Your Ref: OWPC21546
Our Ref: K/3/19/HH 18-01-2019
Please ask for:
Zac Denton

Revised finishes to first floor elevations & new southern boundary wall & gates.
Fynings Middle Way Kingston

Thank you for your internet representation made on 22nd February 2019 which has been recorded as '**an objection**' with the comments as follows:

Drawing: **WALL & GATE DETAILS**

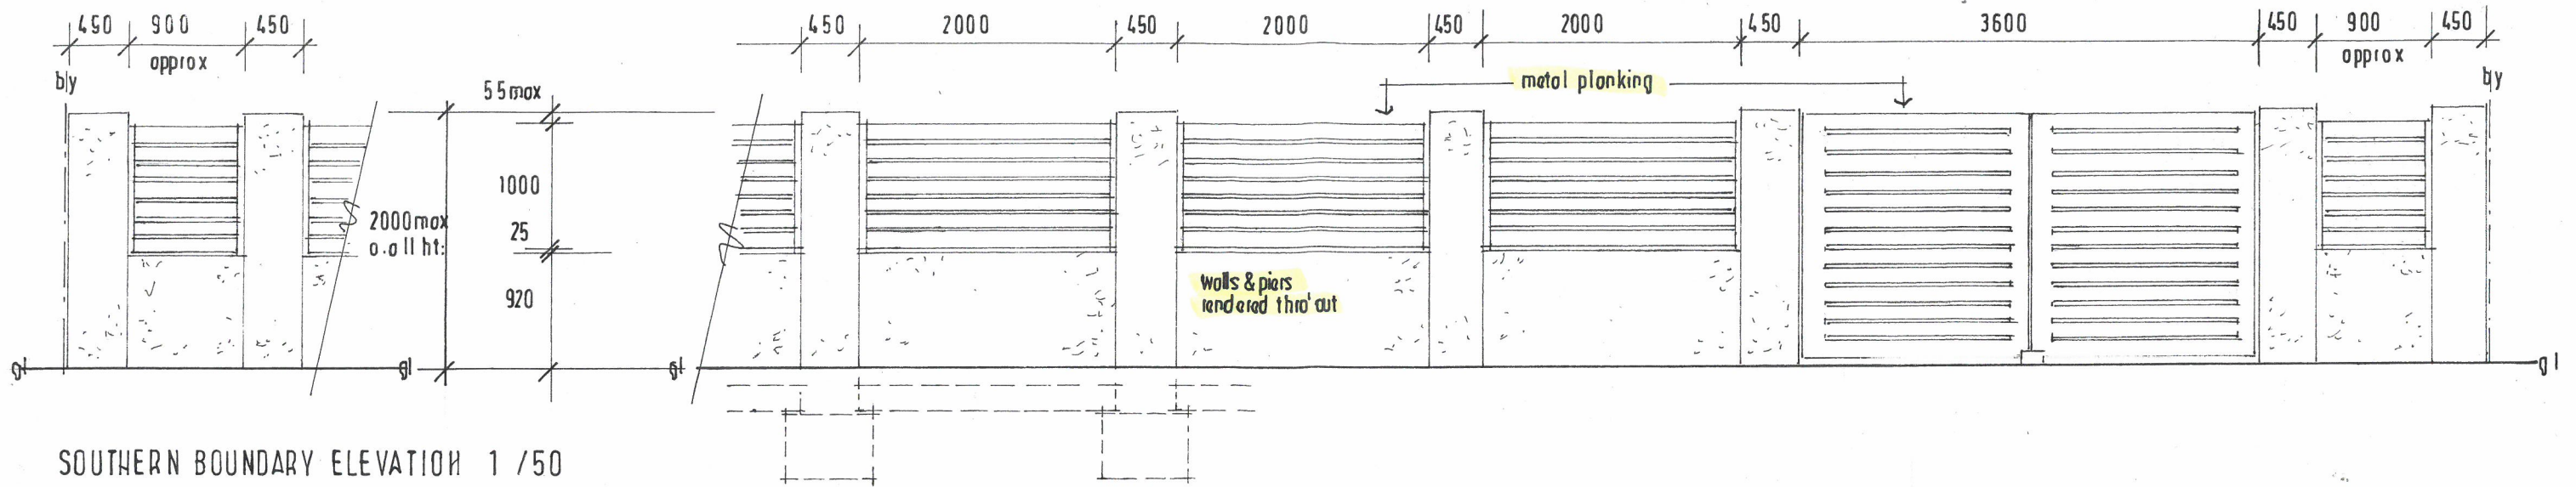
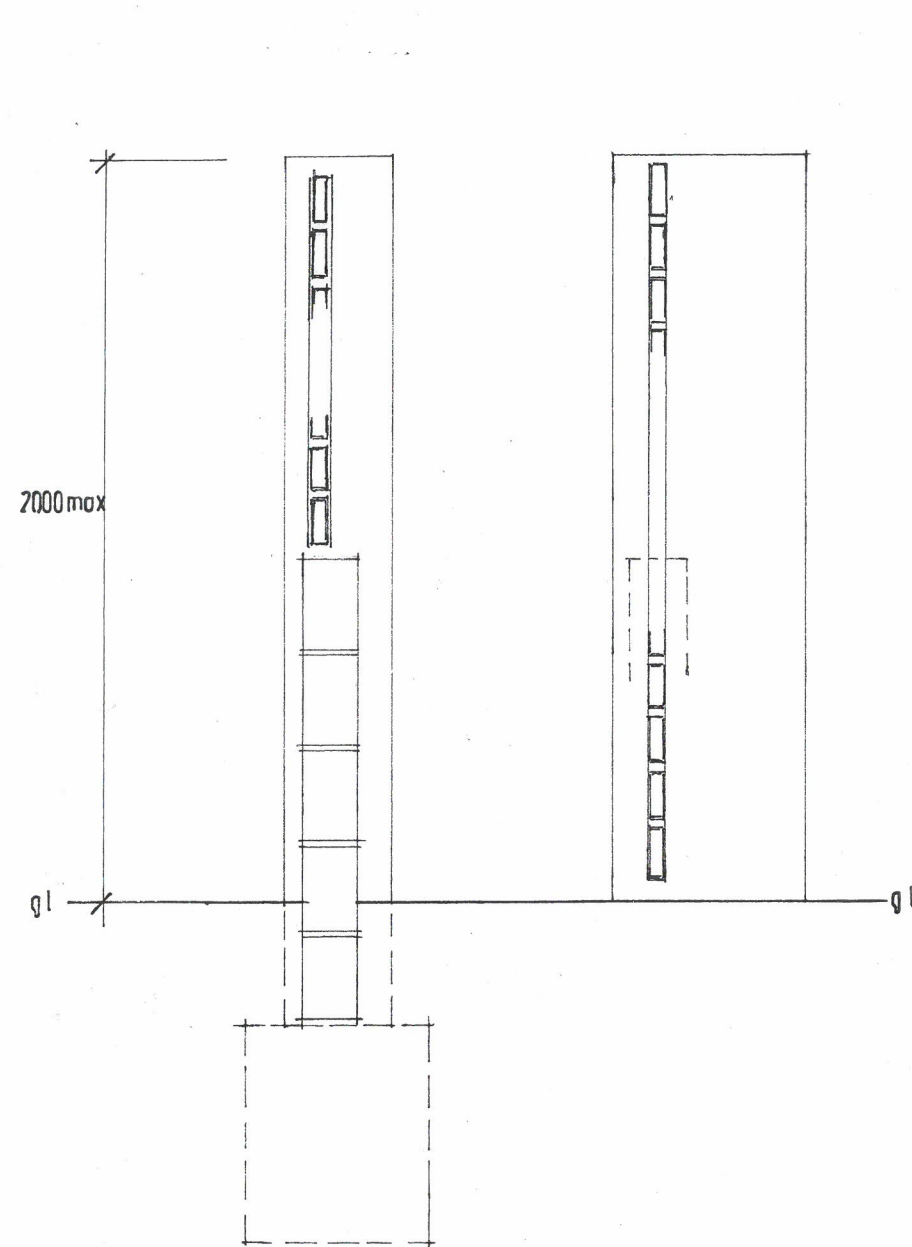
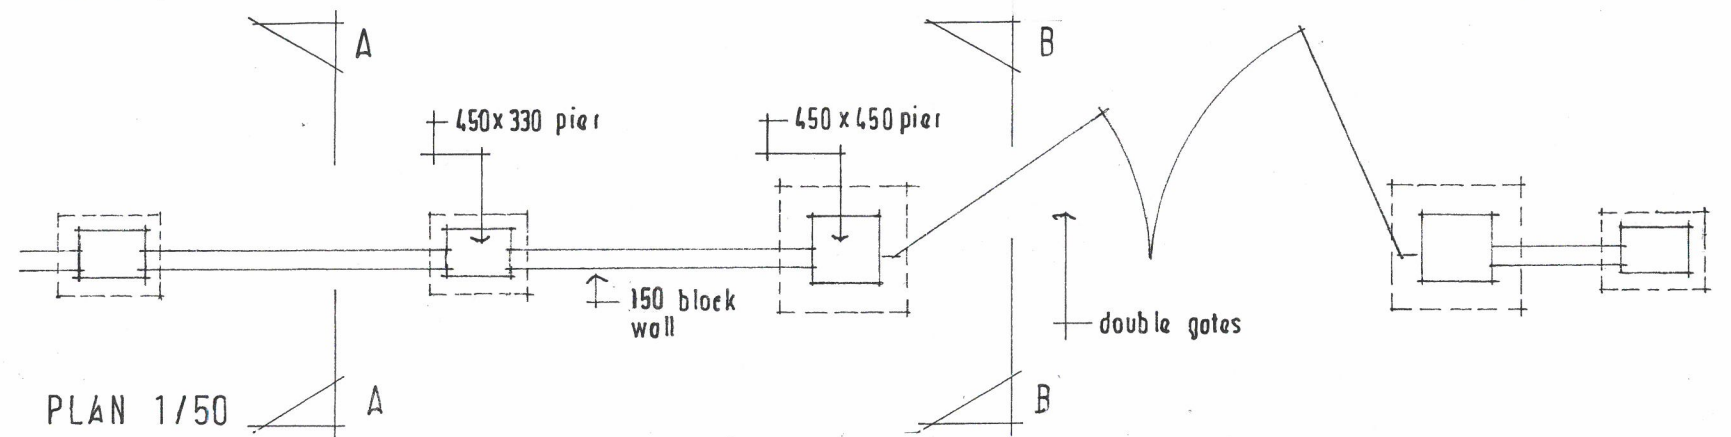
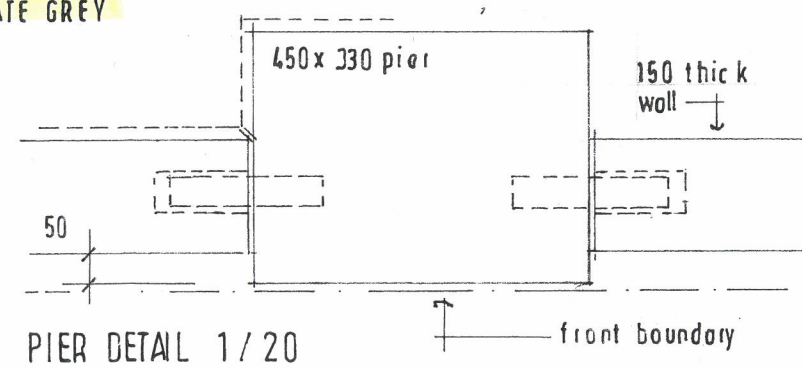
The application proposes that the existing materials of the roof and walls, which are clay tiles and colour washed render, should be replaced by slate grey tiles and a combination of white render and silver grey Eternit boards. The front boundary hedge should be replaced by a 2 metre high wall of white render and grey aluminium planks.

The present finishes and boundary treatment of the plot are typical of the area. The proposed changes would therefore create a house that was a sharp contrast to the character of the area. Policy D DM1 of the Arun Local Plan states that development should reflect or improve upon the character of the site and the surrounding area in terms of, inter alia, materials (colour, texture) and landscaping. The proposed changes to materials and boundary treatment in this application clearly breach the conditions of this basic policy of the Local Plan.
